November 13, 2015

Laurie Leader
Plan Review/ Code Enforcement
City of Portland, Maine
Inspections Division
389 Congress Street
Portland, ME 04101

Re: Renovations and Additions to the Park Danforth - BP#2015-01730

REVISED BISTRO HVAC - A1 - SHEET MH1.1A

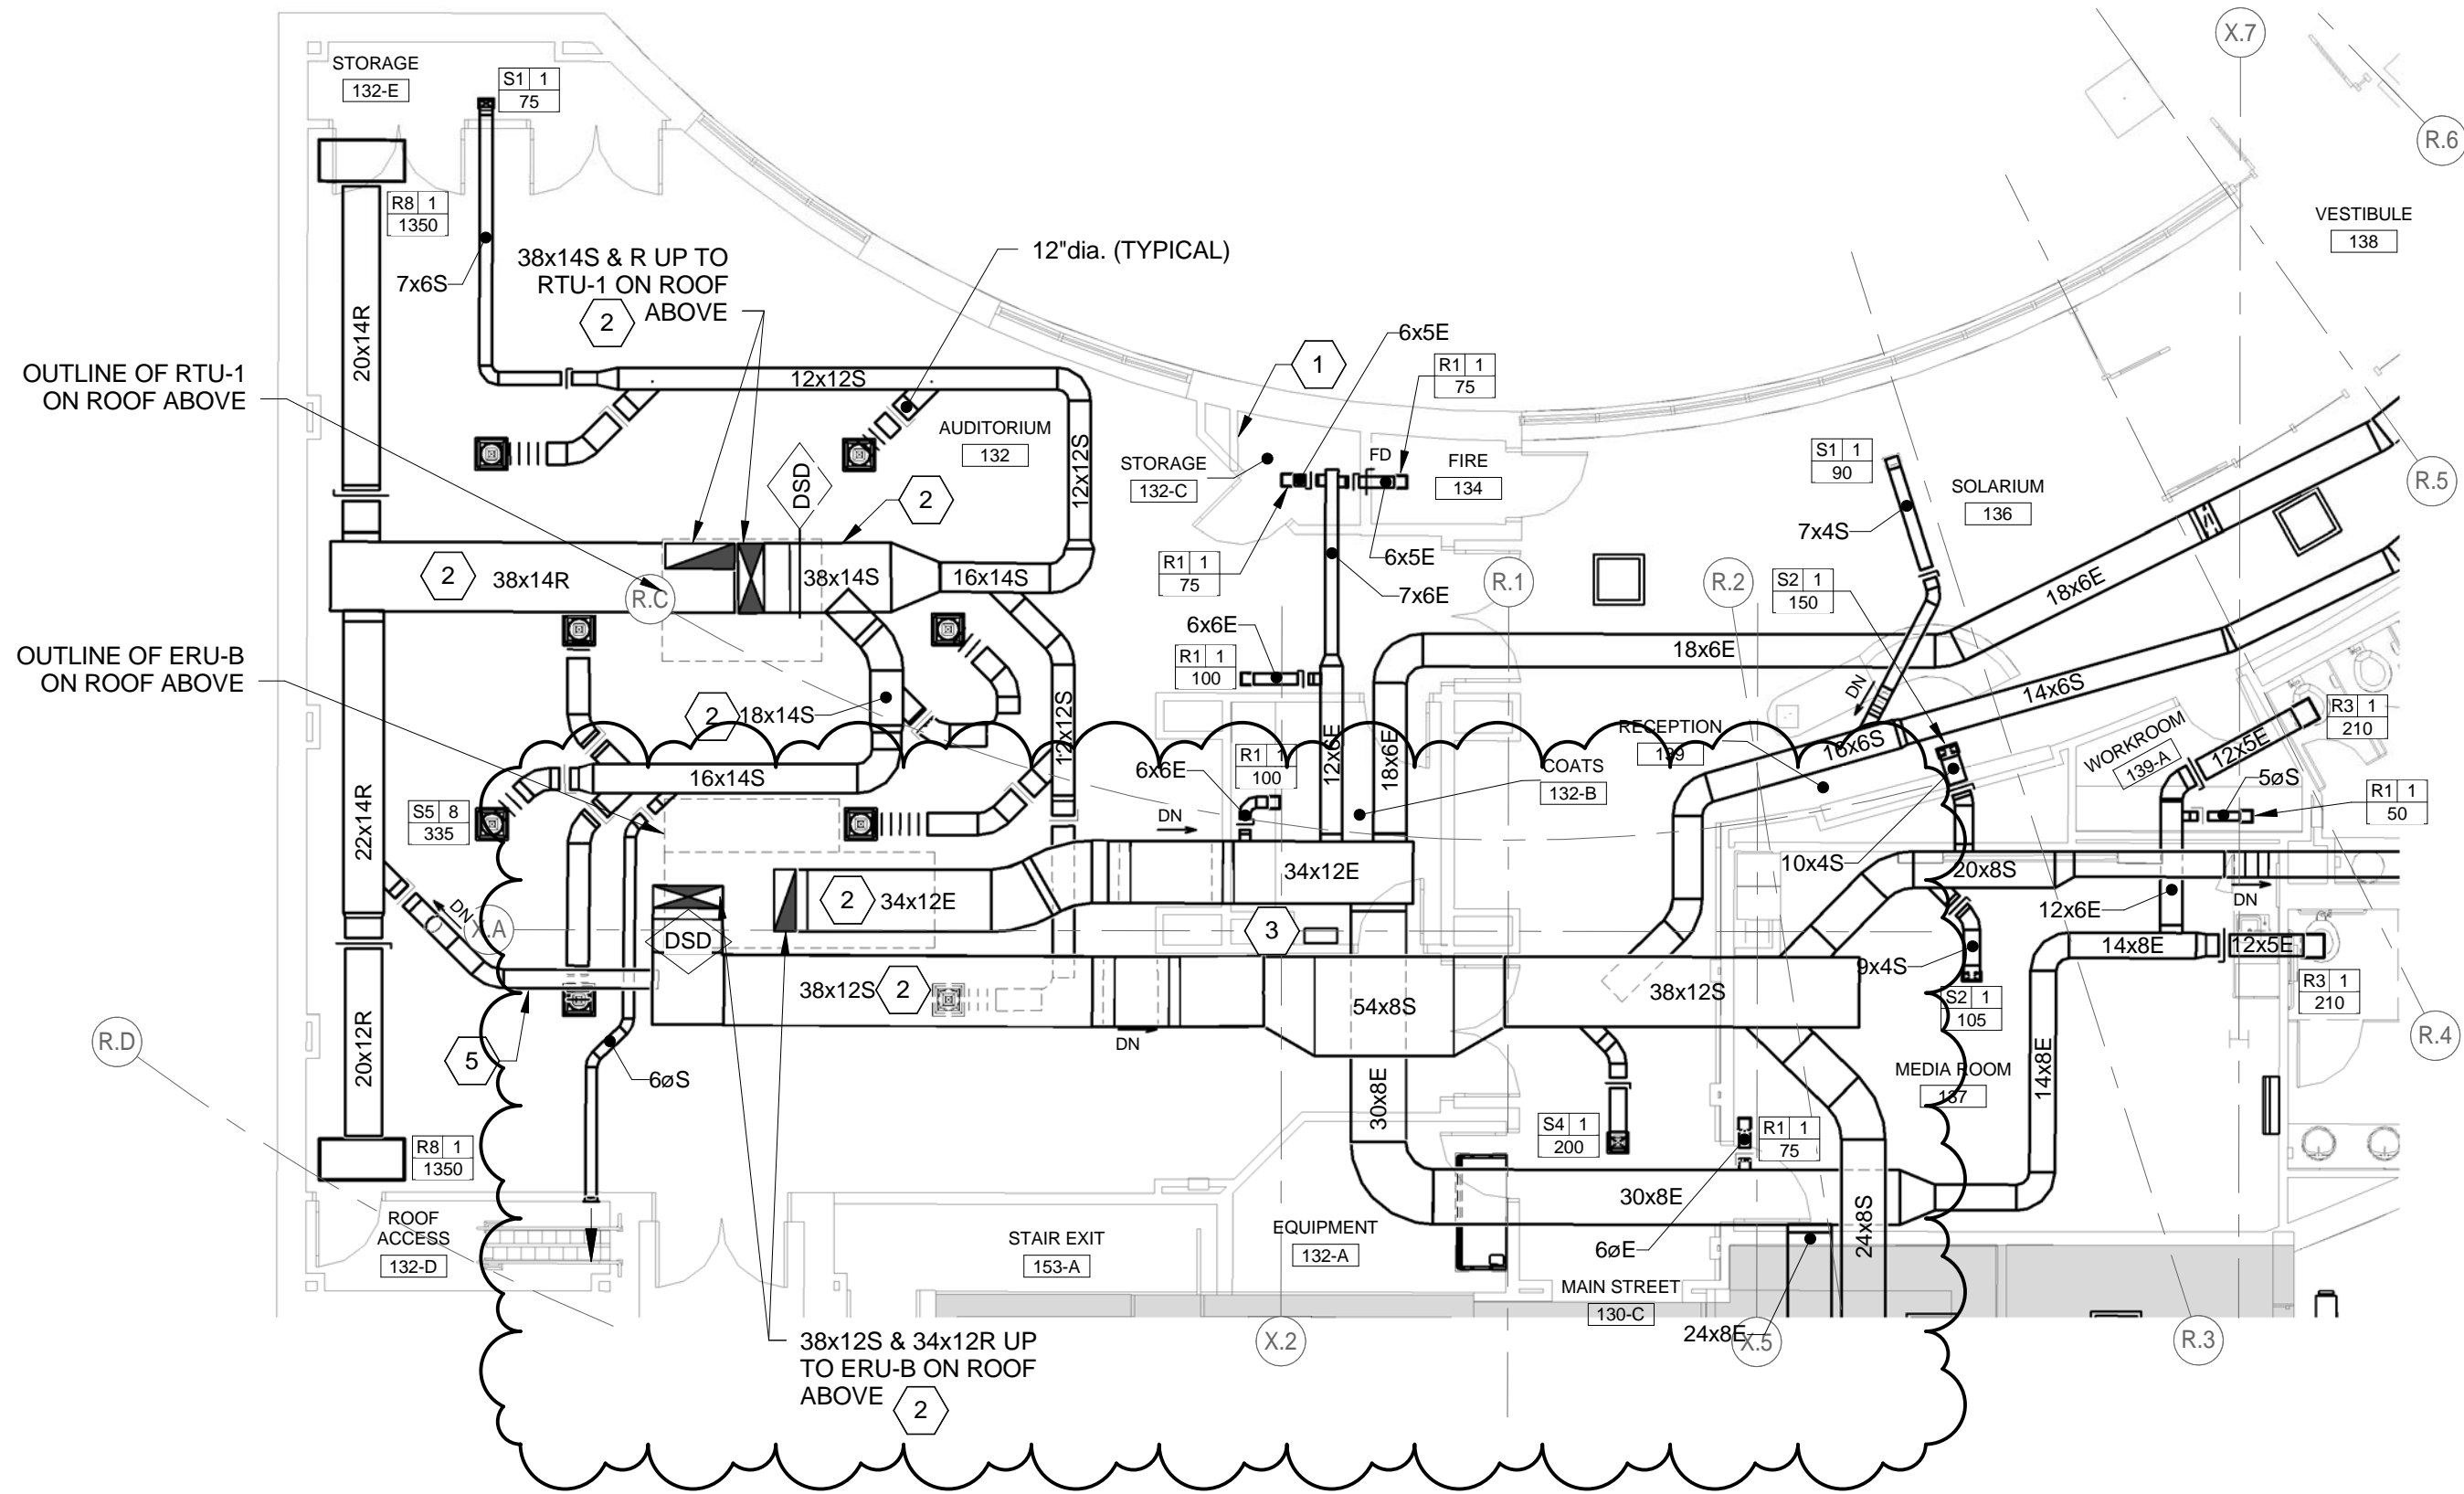
1. *"Please clarify if the parking garage meets IBC section 406.4.2 Ventilation for enclosed parking garage."*
LBA Response: Yes ventilation has been provided. In general, Garage Exhaust G014 (located at juncture of column lines H/11.2) is the main exhaust from the garage area. Fresh air is provided into the garage from ductwork assemblies located at Fire Pump Room G007 (located generally at juncture of column lines B/1.5). This can be further clarified on drawing MH1.0C. Ventilation design is in compliance with the International Mechanical Code
